1 July 2014

**BENGALLA MINING COMPANY DEVELOPMENT CONSENT MODIFICATION 5 ENVIRONMENTAL  
ASSESSMENT - RESPONSE TO SUBMISSIONS**

Indicative Test Pit and Borehole Locations

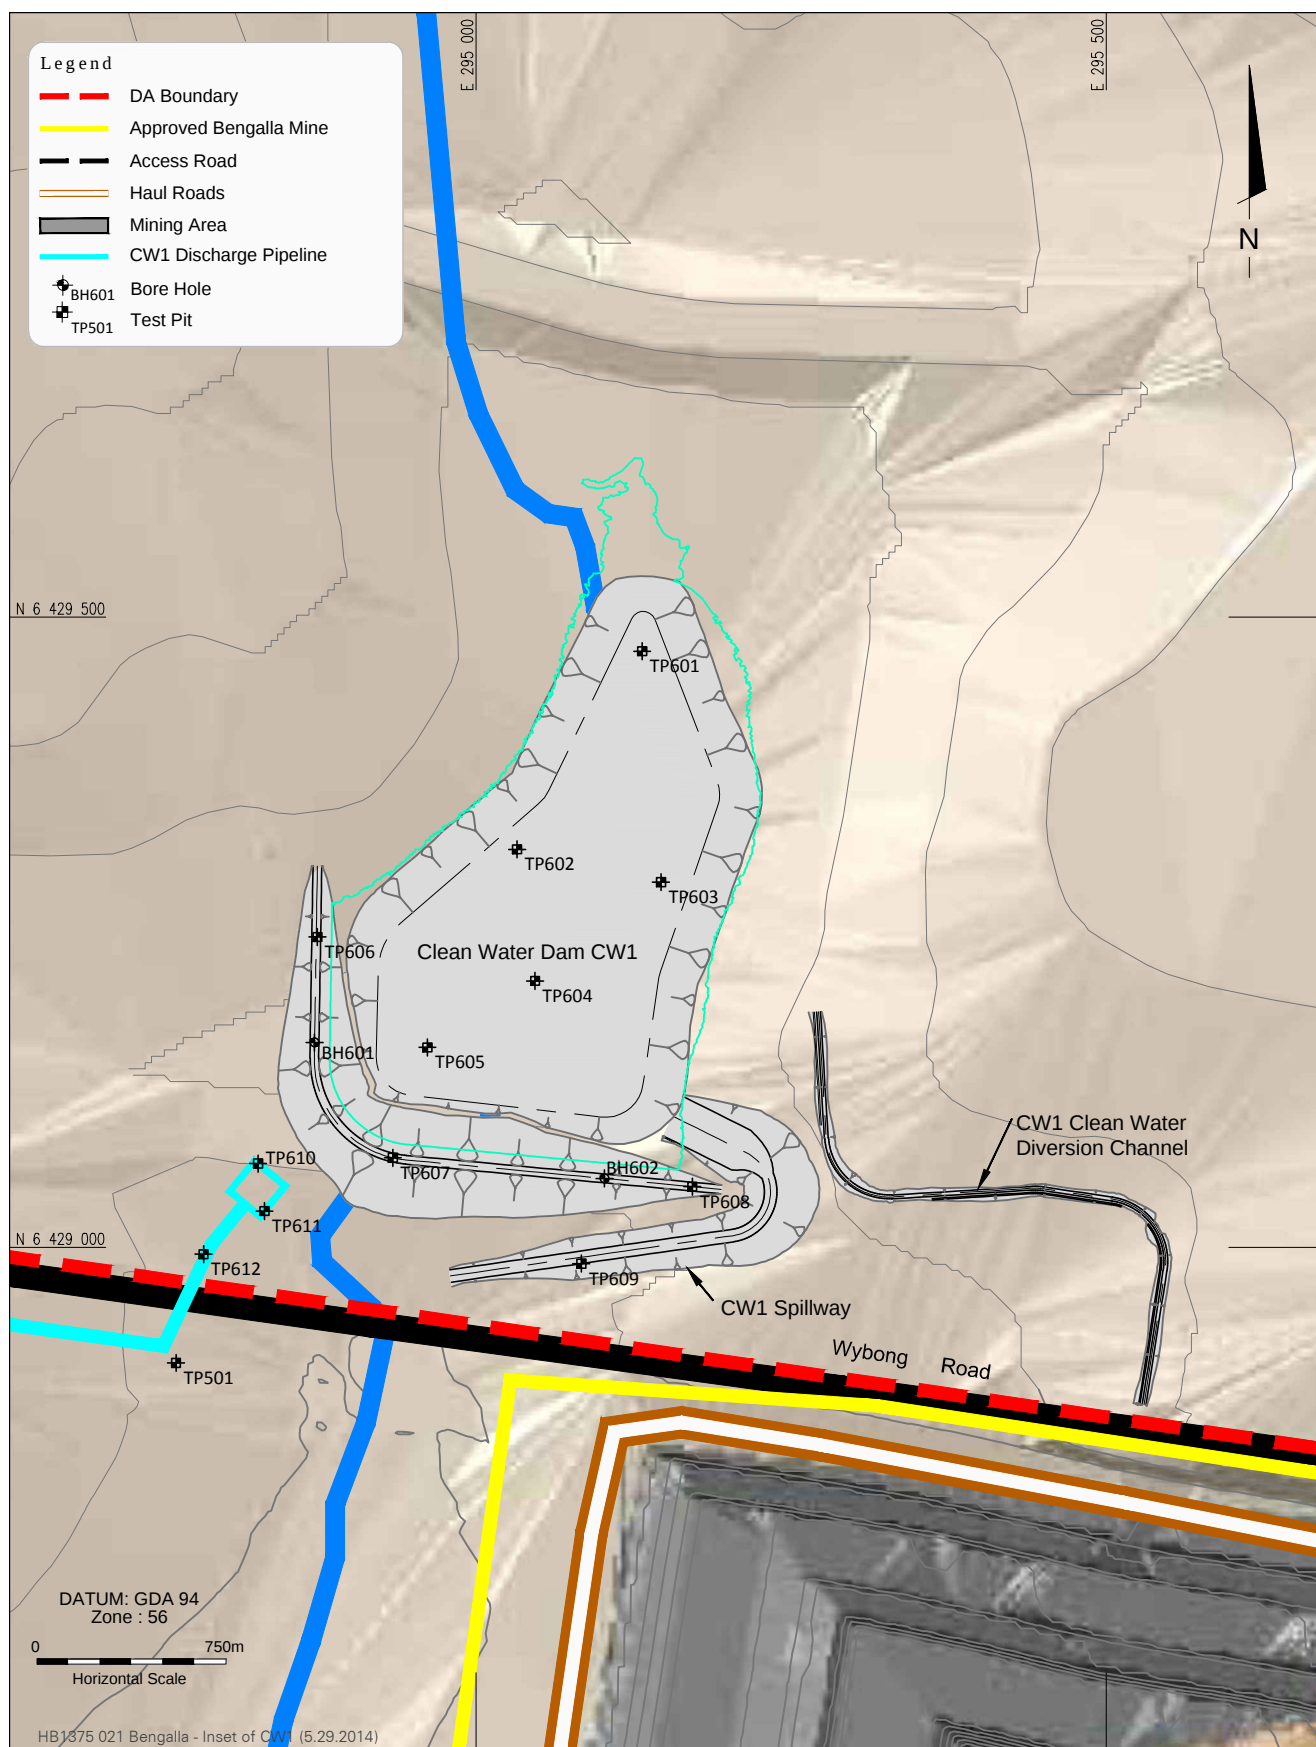
In addition, NOW noted that for any geotechnical investigations proposed within 40 m of Dry Creek then the Guidelines for Controlled Activities on Waterfront Land should be considered prior to commencement of these works.

To ensure the geotechnical activities will not impact on Waterfront Land, all relevant test pits currently within 40 m of Dry Creek (TP 601, 603, 604 and 607) will be relocated to a suitable location further than 40 m from the Dry Creek bank. This commitment has been reflected in **Table 1** (Ref 16). All revised locations will be subject to both ecological and archaeological due diligence assessments prior to completion of the geotechnical investigations.

16.	<b>Geotechnical investigations will not be completed within 40 m of the Dry Creek bank.</b>	This Correspondence
17.	All land disturbed by the proposed geotechnical investigations will be rehabilitated to pre disturbance conditions following the completion of each test pit/bore hole.	5.6.2

Aboriginal Archaeological Sites and Test Pits

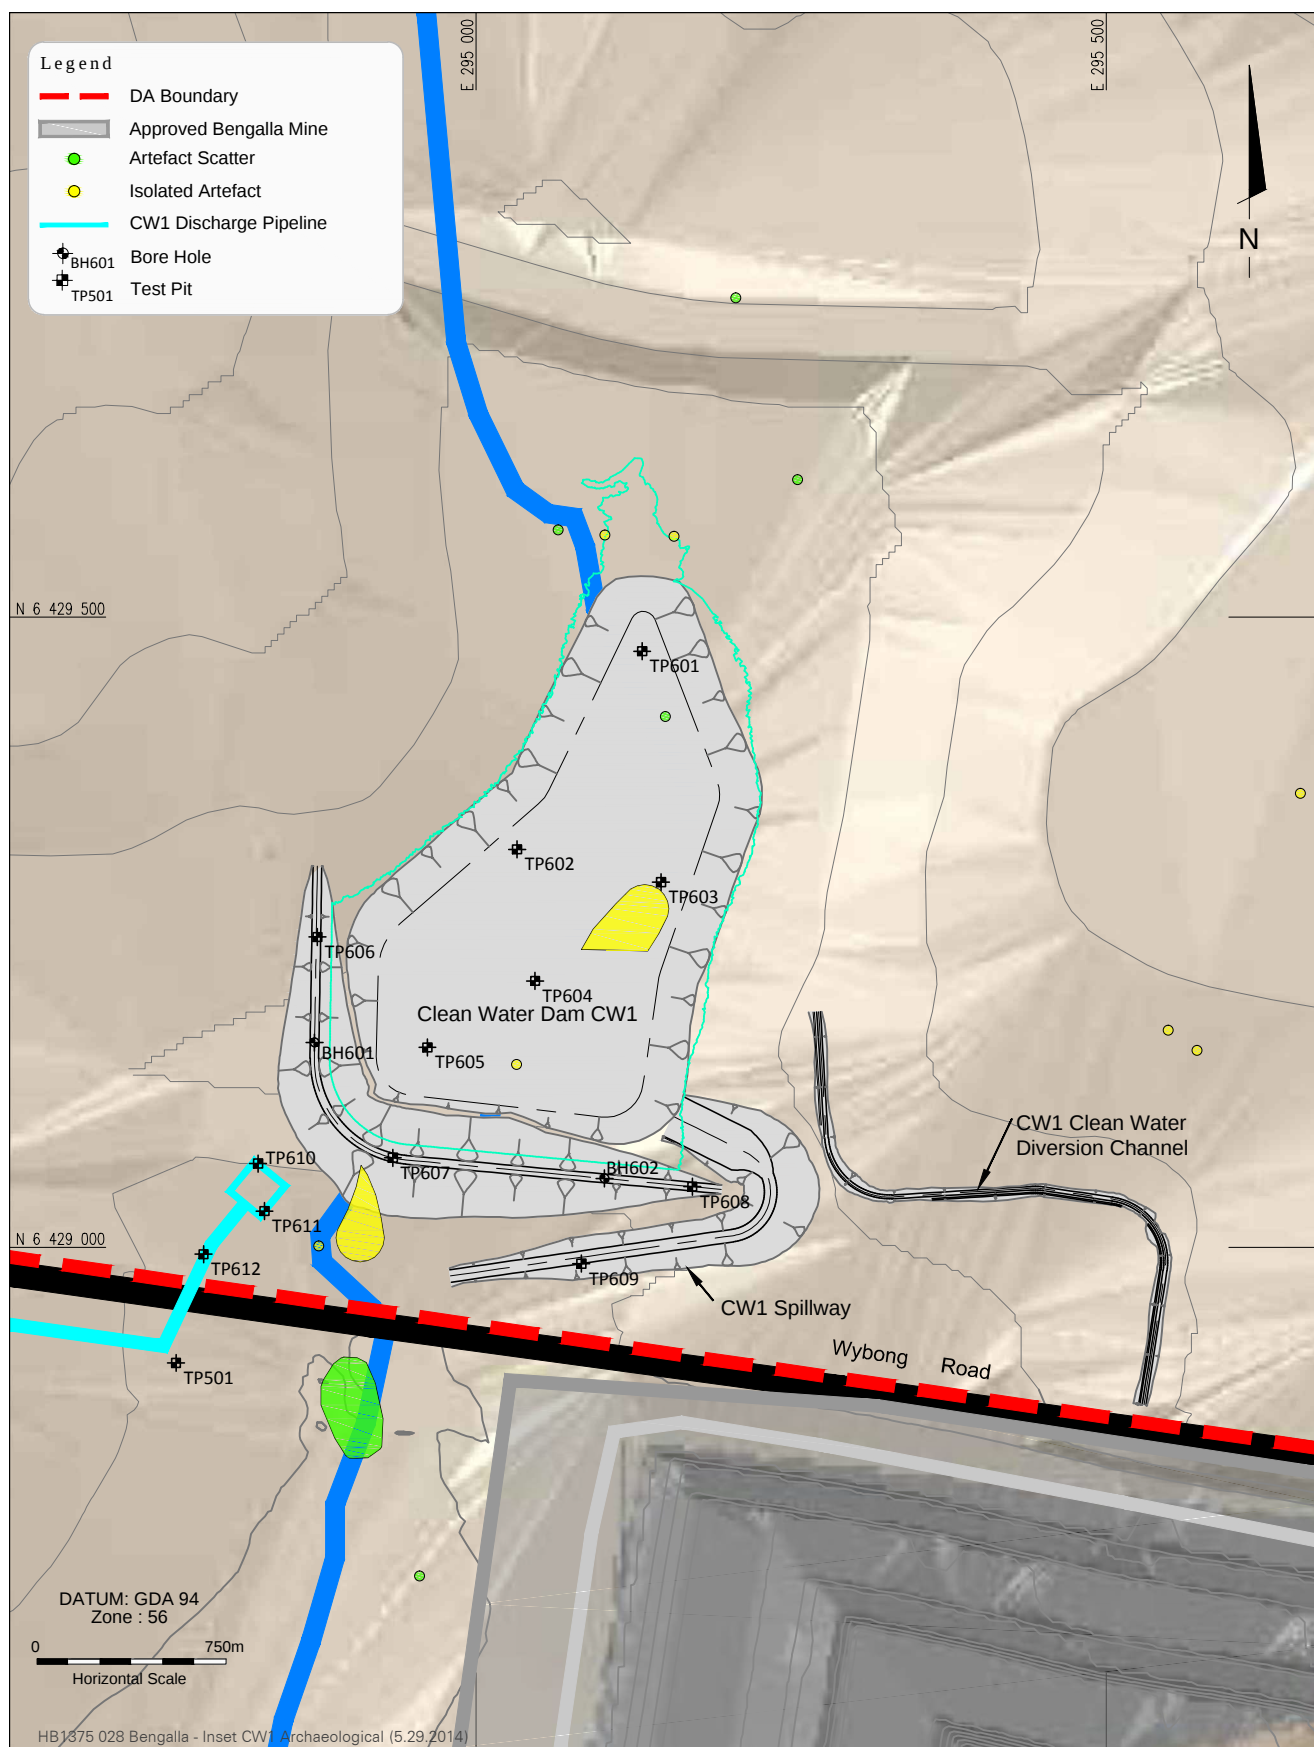
*OEH notes that the proposed geotechnical activities 'may' disturb at least 21 recorded Aboriginal objects (isolated artefacts) and that the archaeological significance of these is considered to be low. The proponent has previously indicated that they would obtain a Section 90 Aboriginal Heritage Impact Permit (AHIP) under the National Parks and Wildlife Act 1974 to either destroy or salvage these artefacts before any construction works start.*

1. *That a Due Diligence Aboriginal Archaeological Assessment under current 2010 OEH guidelines for each test pit and borehole site be undertaken by a suitably qualified heritage professional;*

2. *All recorded Aboriginal objects be clearly marked and suitably fenced off to ensure no impact occurs;*
3. *Access to the test pit and borehole locations is clearly demarcated to ensure that all disturbance is contained within the designated footprint;*

Section 5.2.1 of the Bengalla EA states that the geotechnical activities have been specifically designed to avoid all previously identified Aboriginal artefacts to ensure no impacts occur to any items/place of Aboriginal cultural significance as a result of the Modification.

Further to the above, Section 5.2.2 of the Bengalla EA states that in order to ensure no impacts will occur to previously identified or unidentified Aboriginal archaeology a due diligence assessment will be completed by a suitably qualified person prior to disturbance and test pits and boreholes relocated as required.

Given the abovementioned mitigation measures, the Modification will not impact on any Aboriginal artefacts (known or otherwise) and no Section 90 AHIP would be required.
